CITY OF ALBUQUERQUE

March 17, 2023

**Re: Raising Cane's
4800 Montgomery Blvd. NE
30-Day Temporary Certificate of Occupancy
Transportation Development Final Inspection**
Engineer's Stamp dated 07-07-22 (G17-D011)
Certification dated 03-14-23

SITE KEYNOTE PLAN

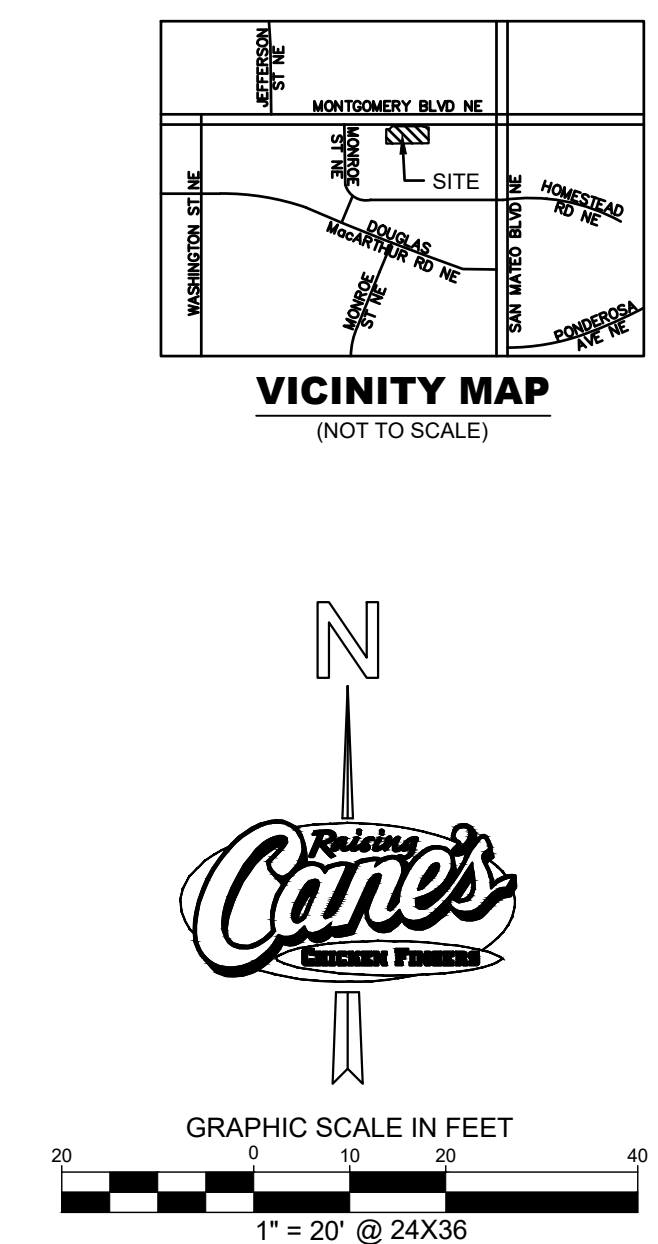
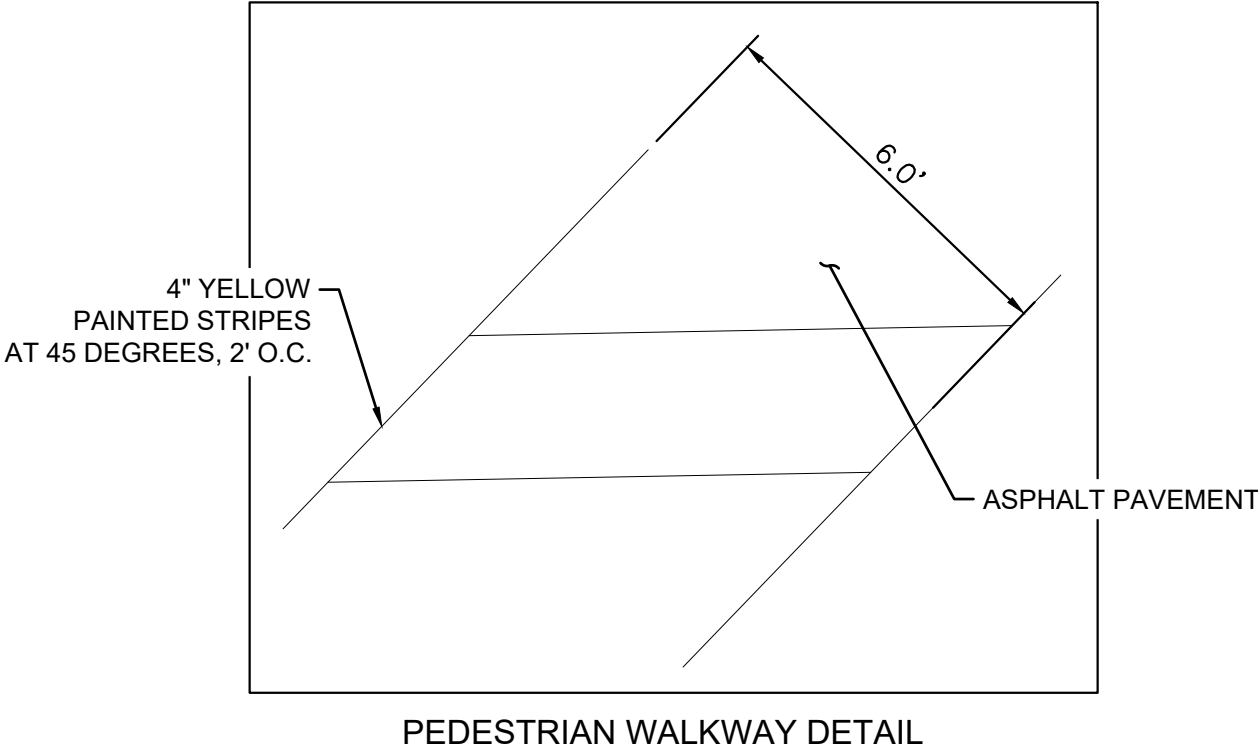
- Key note G.2: Per City standard the dimensions for the ADA ramp's turning space should be minimum 5'X5'. But per site visit the length is exactly 4'. Please re-build this ramp per COA std dwg 2442 as referenced on the approved site plan. See attached photo.
- Please provide Motorcycle parking posted upright sign, either free-standing or wall mounted per the zoning code.
